# Norfolk County Council

## Sheringham Shoal & Dudgeon Extension Projects Norfolk County Council's response to the Examining Authority's (ExA) Third Written Questions (WQ3)

Scheme Identification Number: *EN010109*  
Registration Identification Number: 20033126  
June 2023

TITLE  
B1149 OULTON  
DRAFT  
ACC25 ACCESS CONCEPT  
SWEEP PATH ANALYSIS

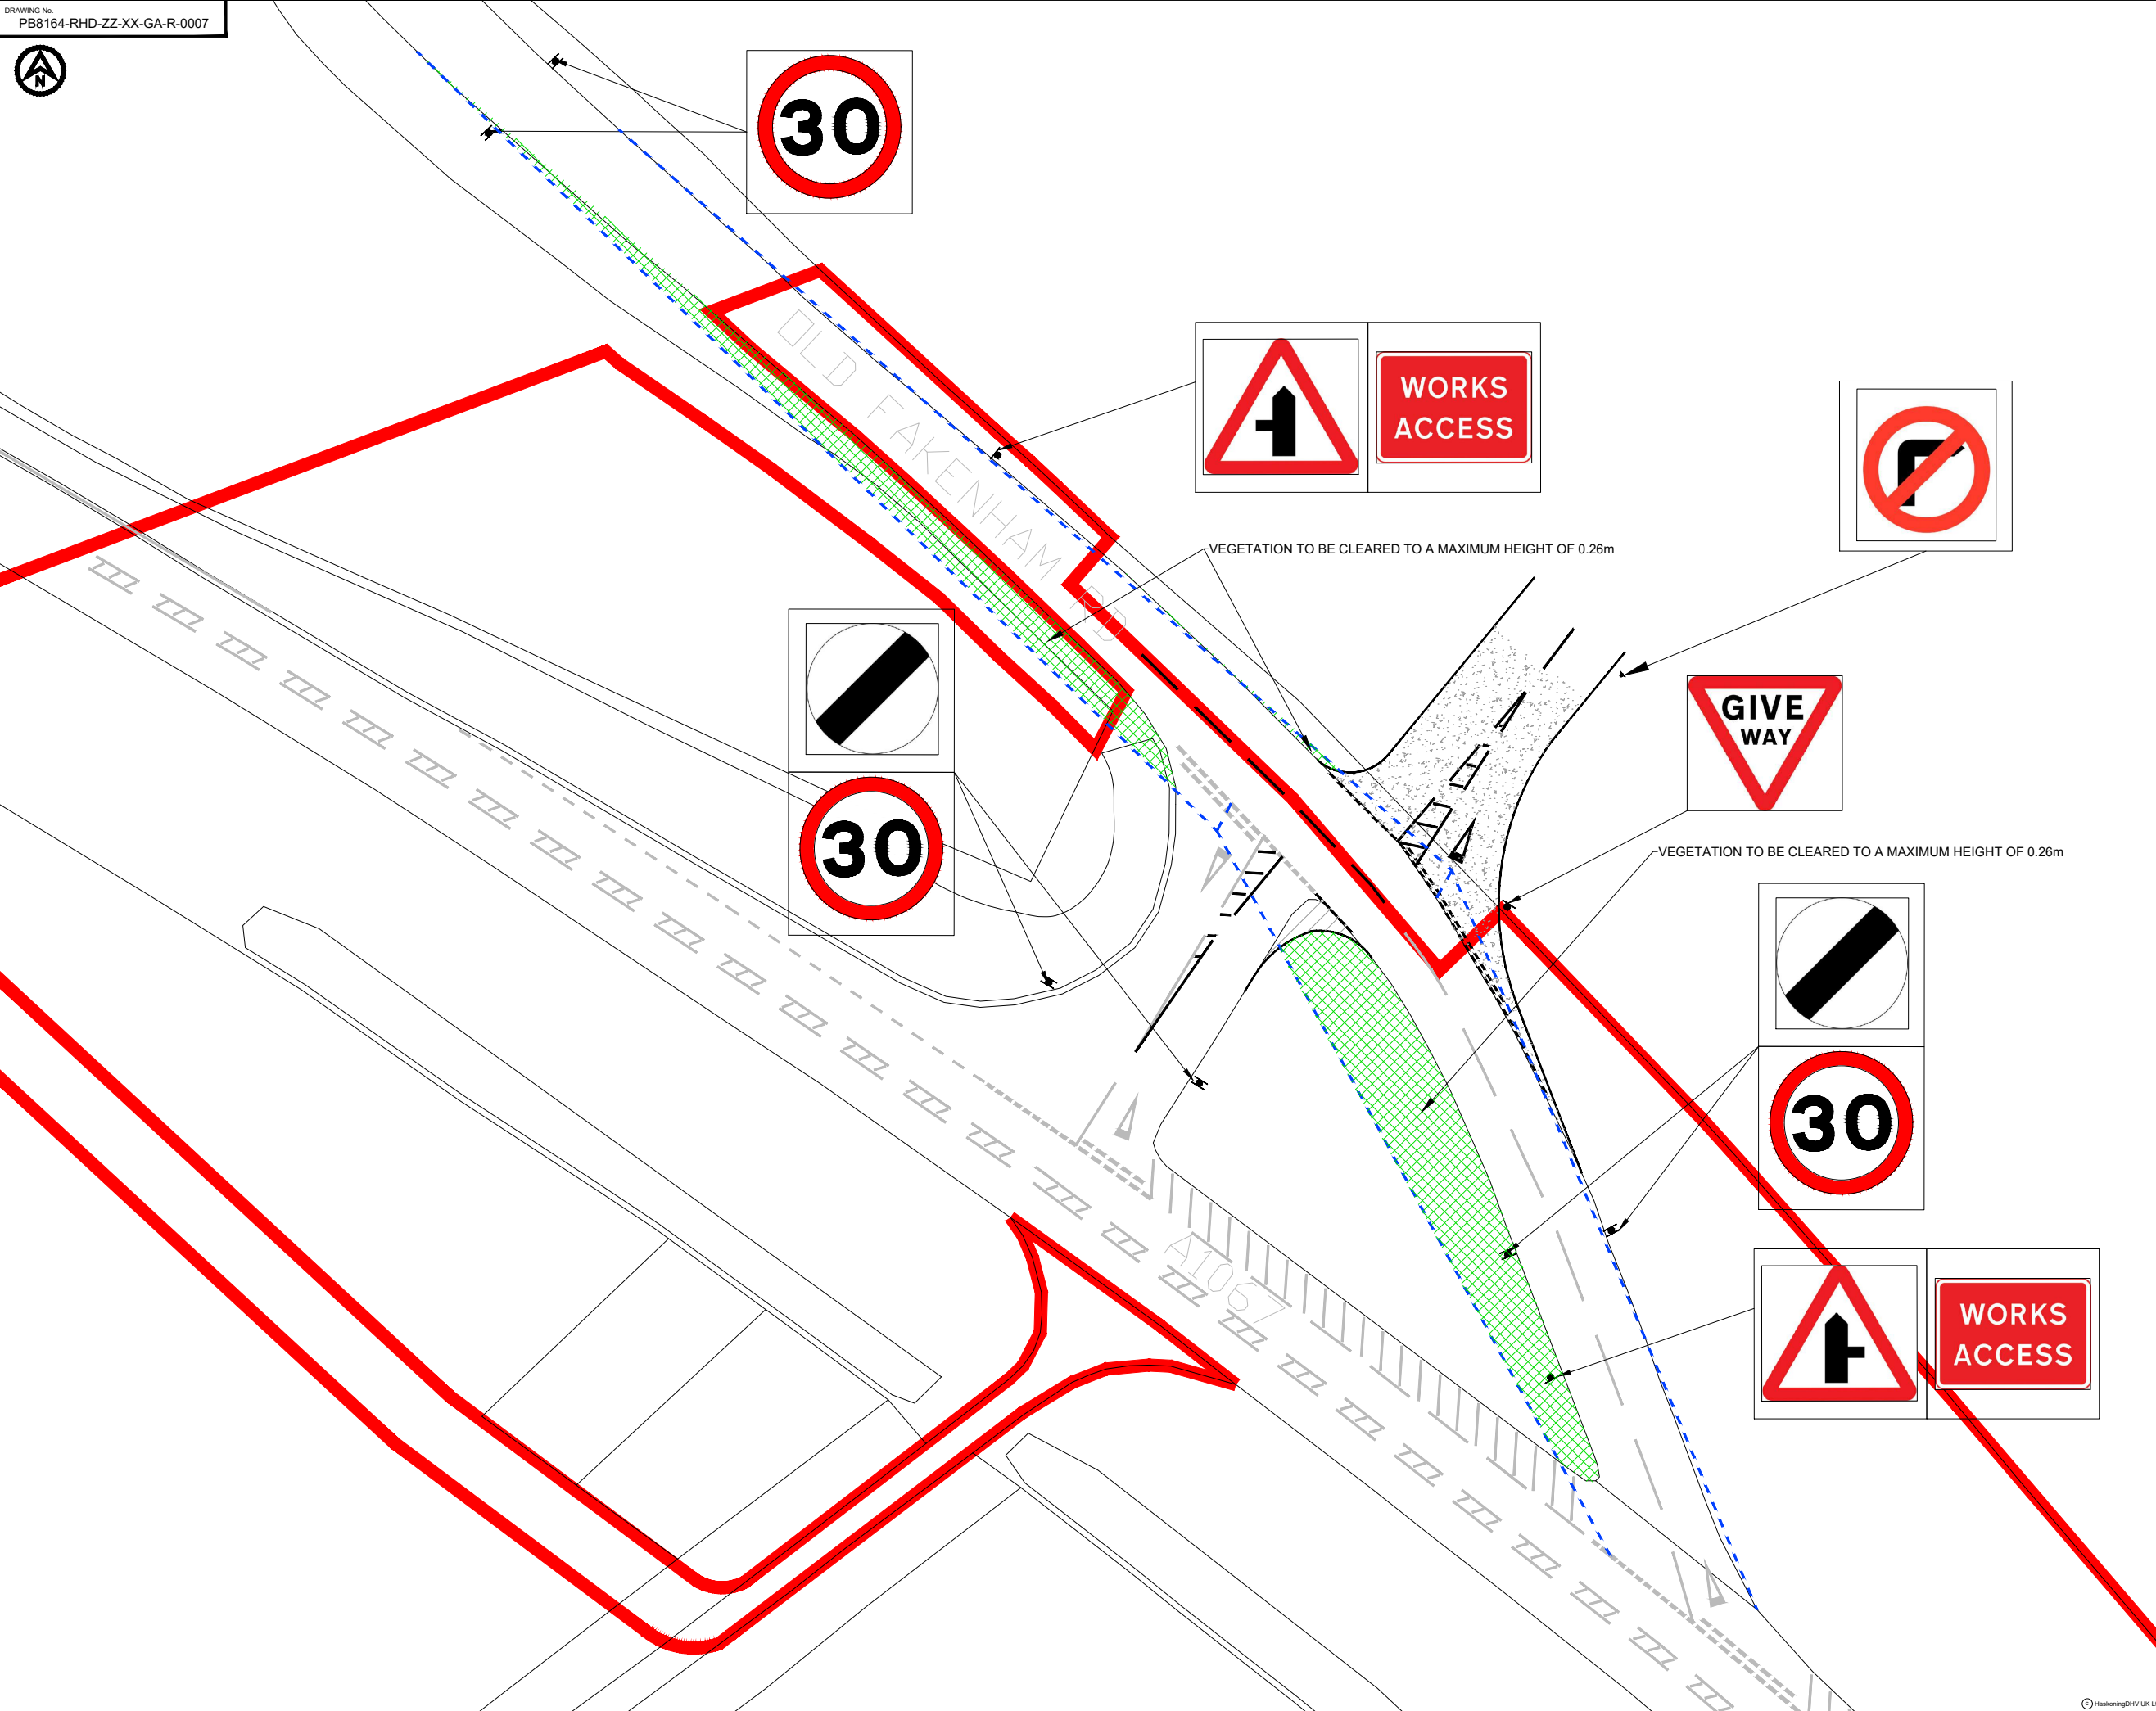
Q3.23.5.2	Applicant Norfolk County Council	<p><b>Accesses ACC25 and ACC25b</b></p> <p>The most recent draft SOCG [REP4-021] with NCC notes that matters associated with access ACC25 and ACC25b and mitigation measures are still in discussion. Provide an update on these discussions.</p>
	NCC Response:	<p>Both access points require a set of lights to operate simultaneously. The two access points are some 800 metres apart, and access point 25b already has restricted working hours.</p> <p>We have held dialogue with the consultants and have agreed additional traffic control measures at AC25b for the hours of operation. In summary:</p> <ul style="list-style-type: none"> <li>• Access from the B1149 to the Sheringham and Dudgeon Extension Projects via both accesses ACC25 and ACC25b will be controlled by traffic signals.</li> <li>• Access ACC25 will be utilised by construction traffic for a period of approximately six months and access ACC25b will be utilised for a period of approximately two months. The Applicants have also confirmed that both accesses may be operational at the same time.</li> </ul>

<ul style="list-style-type: none"> <li>•ACC25b has a greater propensity to induce traffic queuing, therefore further controls are required for this installation to prevent conflicts.</li> <li>•NCC has previously agreed with the Applicant that controls on operating hours for the traffic signals will be required at ACC25b (i.e. not to operate during network peaks). These controls are outlined within the Applicants latest Outline Construction Traffic Management Plan (OCTMP) (Revision C) but need to be extended to ACC25.</li> <li>•NCC have also requested that the Applicants include an additional commitment for the ACC25b signals to operate under manual control (manual control would allow the timing of the traffic signals to be manually adjusted on site to prevent blocking back between the signals). The Applicant has confirmed to NCC that they will include this additional commitment in a revision to the OCTMP at Deadline 5.</li> <li>•No controls on operating hours or method of signal control are proposed for ACC25</li> </ul> <p>Subject to updating the OCTMP at Deadline 5 as per the above, NCC is now content.</p>
